From: Paul Farndale
Sent: 15 August 2017 16:40
To: DCAdmin
Cc: Matthew Woodward
Subject: Serpentine Road, Cleckheaton.
Attachments: Serpentine Road, Cleckheaton, BD19 3NA.docx

We would accept the findings on percolation testing. Ideally photographic evidence of testing is encouraged. However they still promote quite considerable discharge rates to the combined sewer. Previous drainage has not been proved and some areas didn't look like there were positively drained. We believe this figure will be lowered.

Drawing title  
**Drainage Strategy Layout**

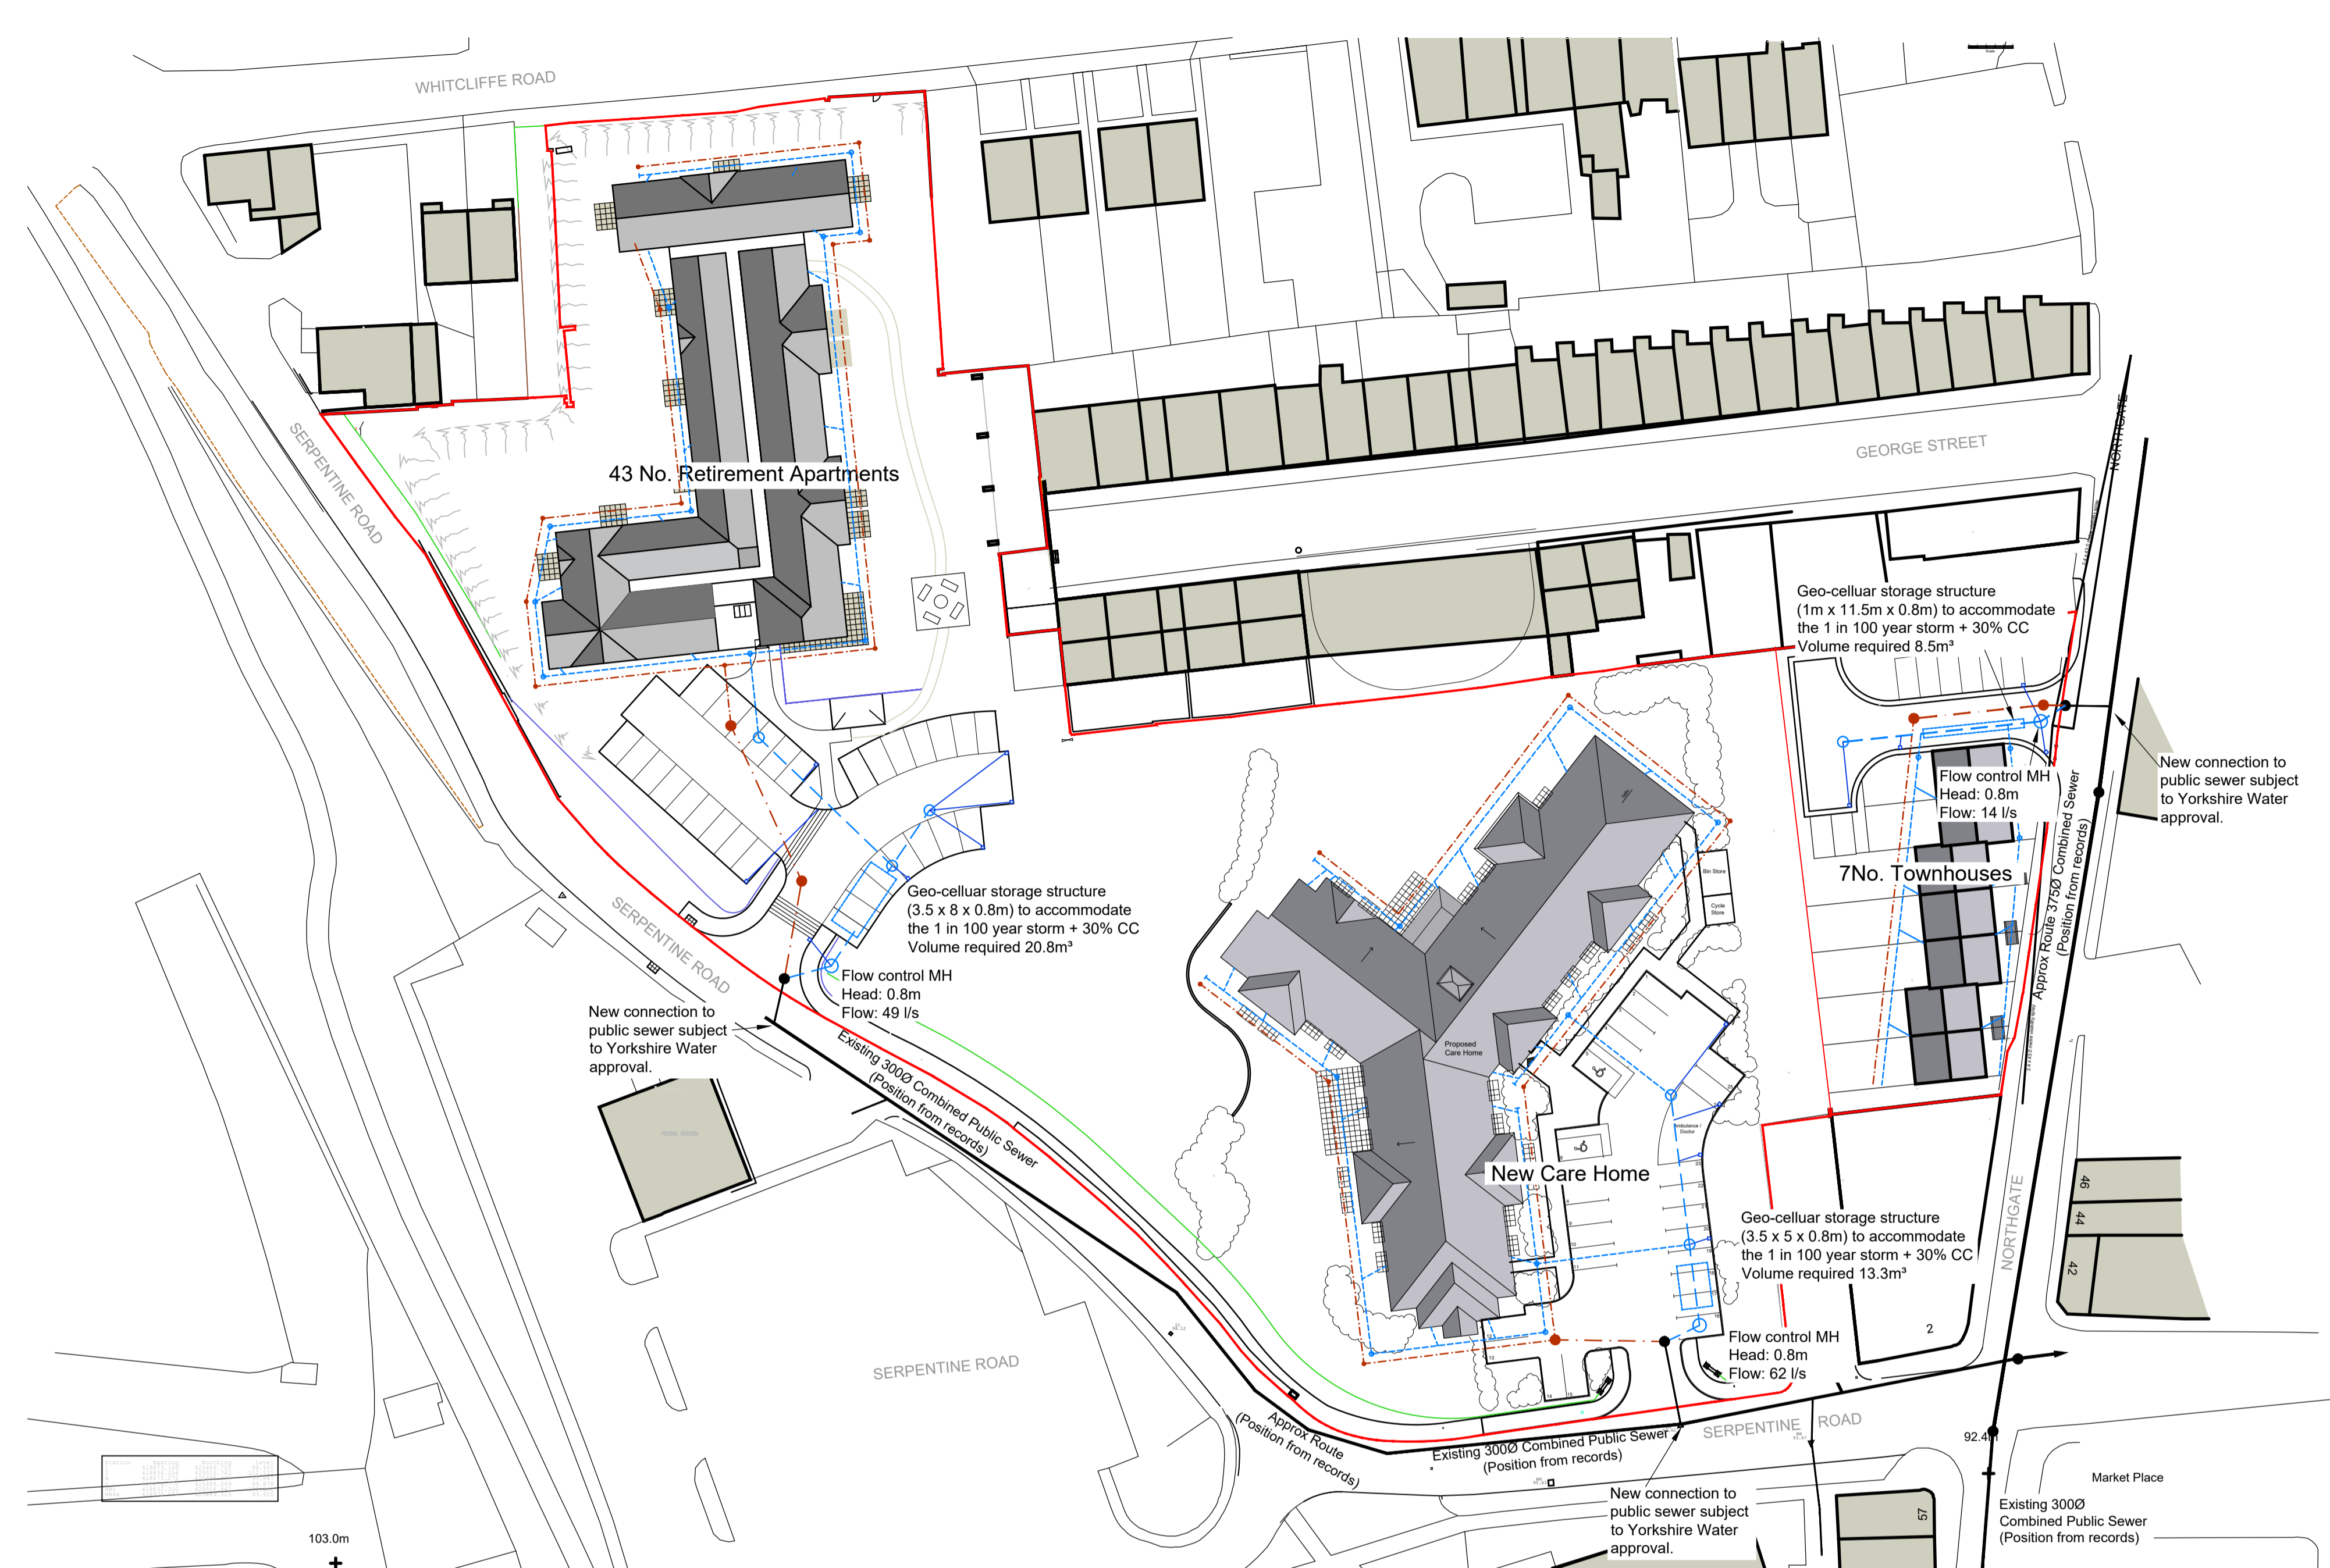
However if YW accept the figures to COMBINED sewer, we do not usually interfere unlike surface water sewers that discharge directly into watercourses.

We could condition drainage now but using STANDARD Kirklees conditions not Yorkshire Water's which have been changed recently and we feel skew the process of analysis and may cause unnecessary delays. This said a steer from Yorkshire Water on the figures supplied would be right and proper at this juncture.
